SUBJECT: PONDEROSA PINE ESTATES. A SUBDIVISION OF LOTS 1 AND 2,
MORGAN SUBDIVISION NO. 1 SECTION 9, T.11S., R.67W. OF THE 6TH P.M.
EL PASO COUNTY, COLORADO

This letter is in response to the last County plat review for the site

PONDEROSA PINE ESTATES

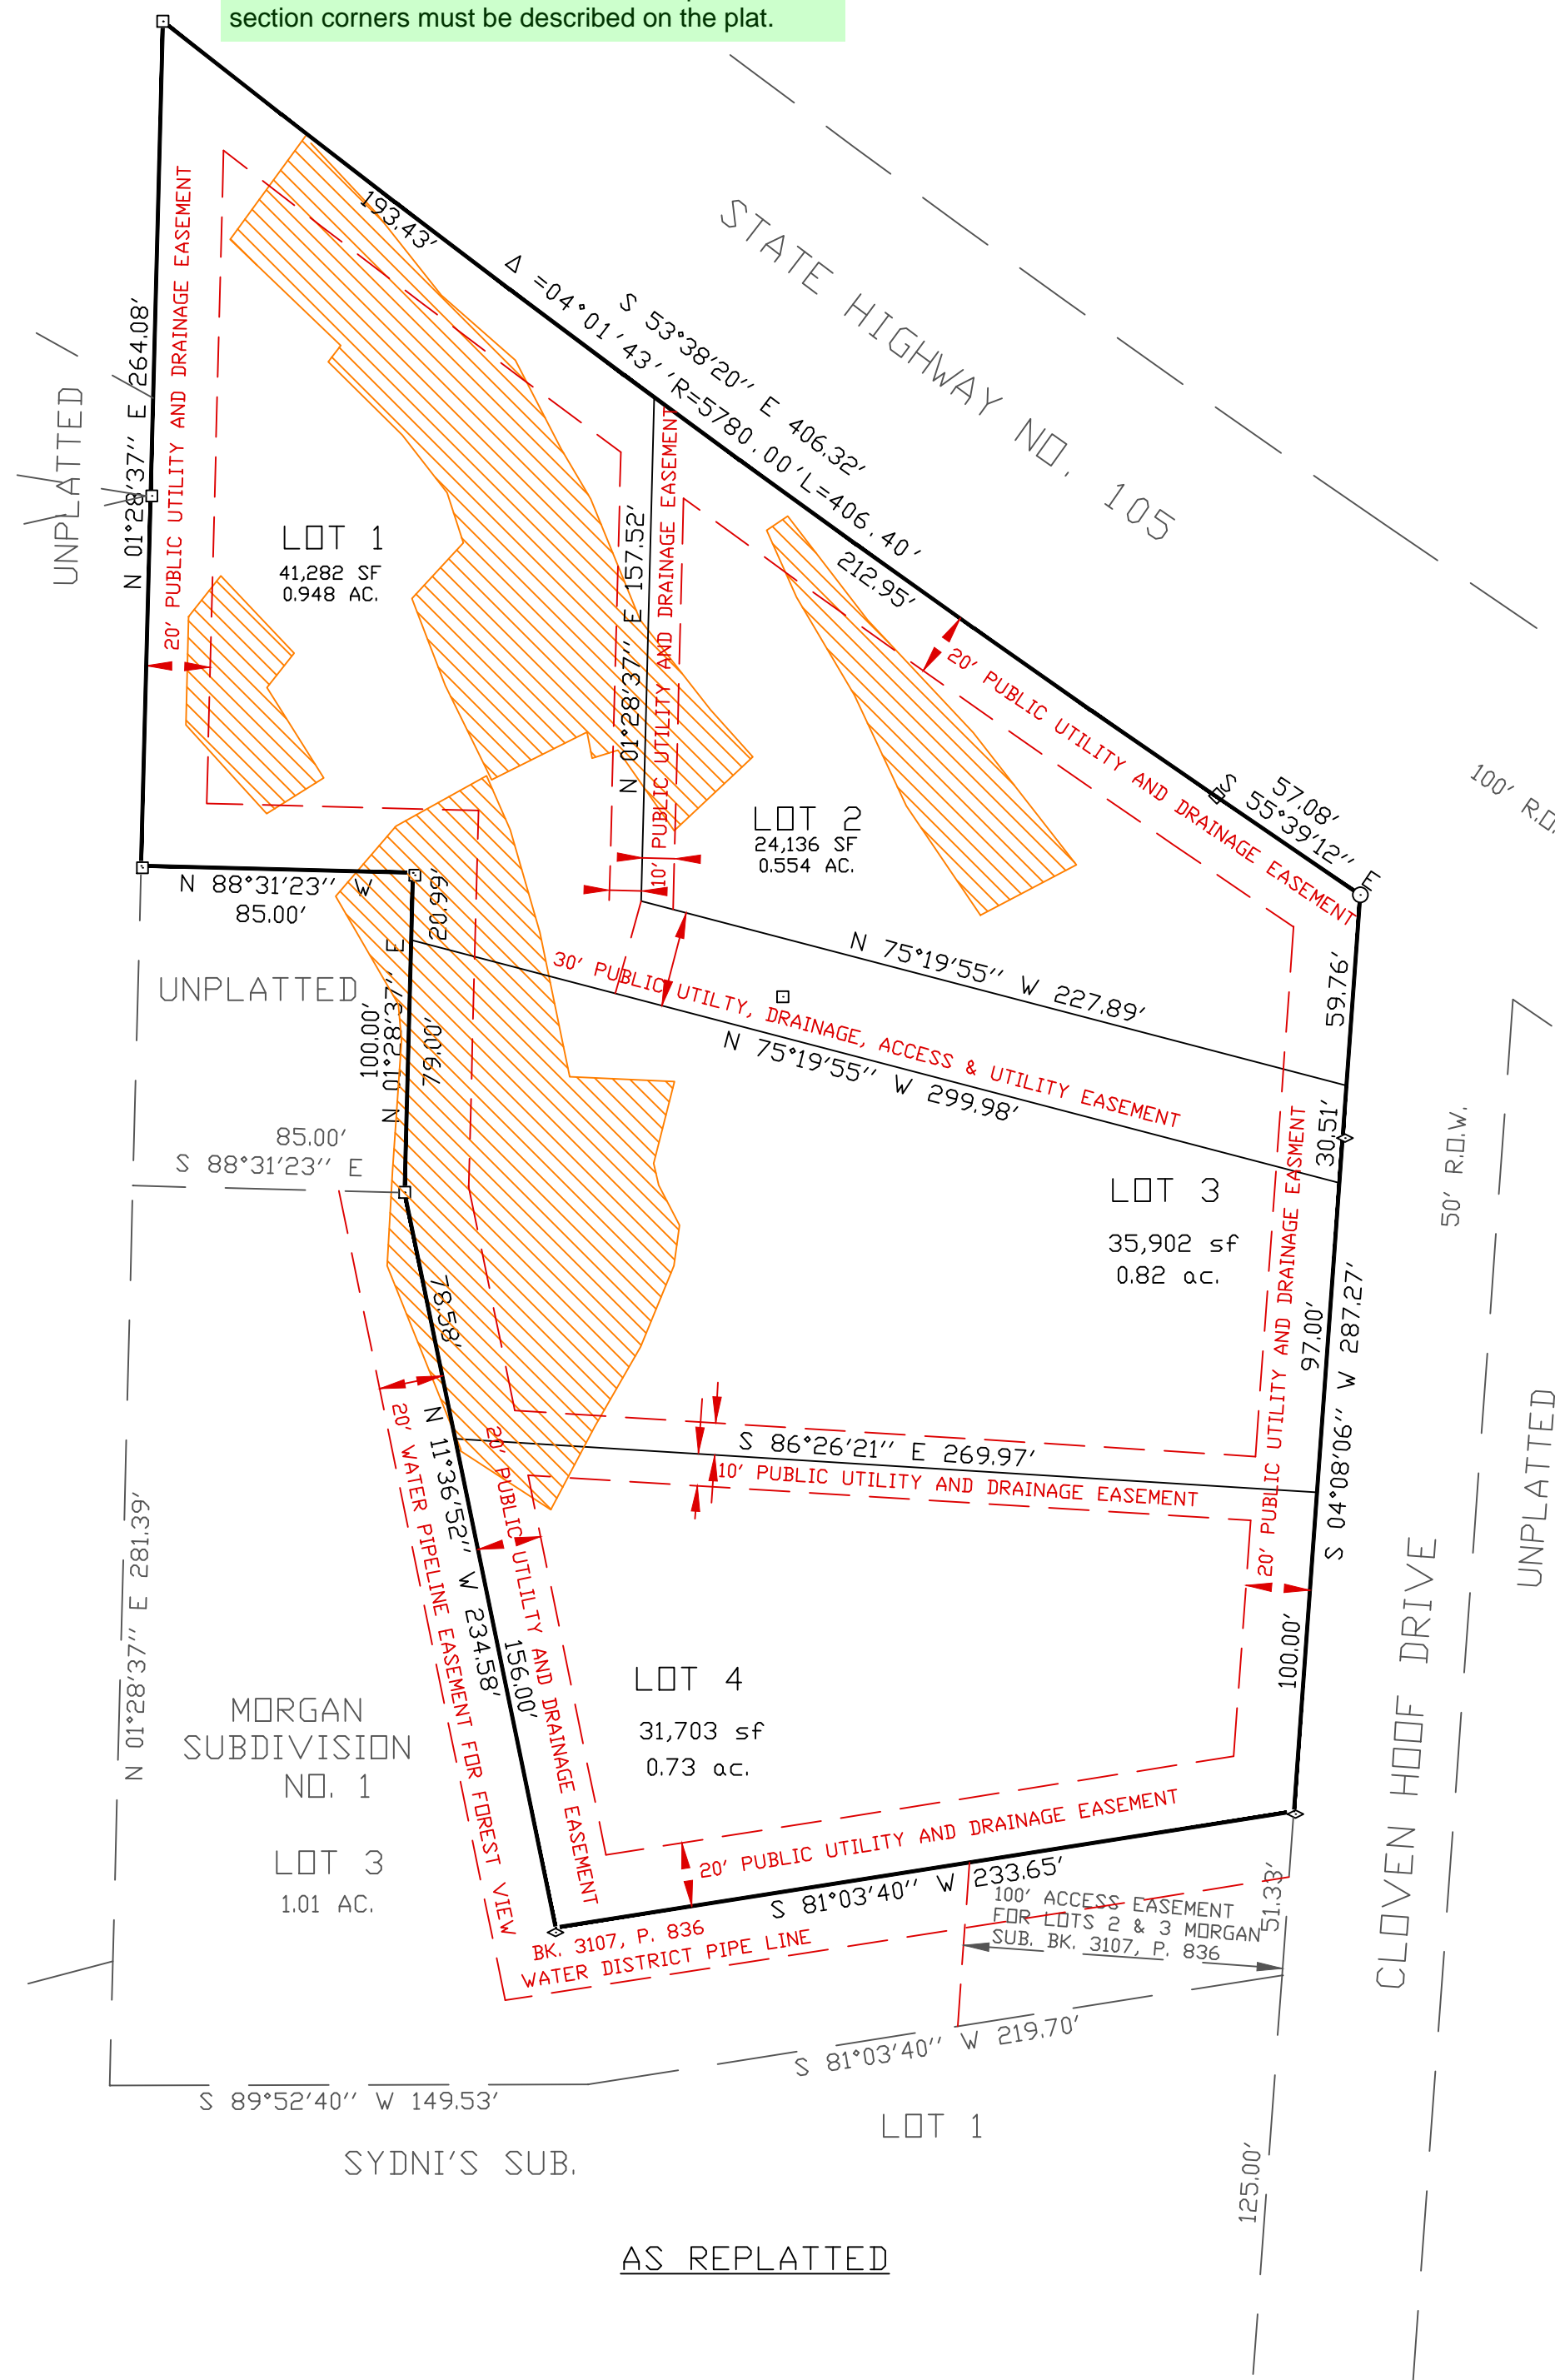
1. The owner's contact information is listed below his signature block on page 1 only
2. You do not list a P.O.B. (point of beginning) for a subdivided lot, as there is none. This site is a replat of 2 lots: LOTS 1 AND 2, MORGAN SUBDIVISION NO. 1
3. There is no State requirement to tie subdivided lots to aliquot corners (Section corners, Quarter corners) since this would have been done with the original subdivision plat of the site: MORGAN SUBDIVISION NO. 1. Ties to aliquot corners should only be done for an unplatted site
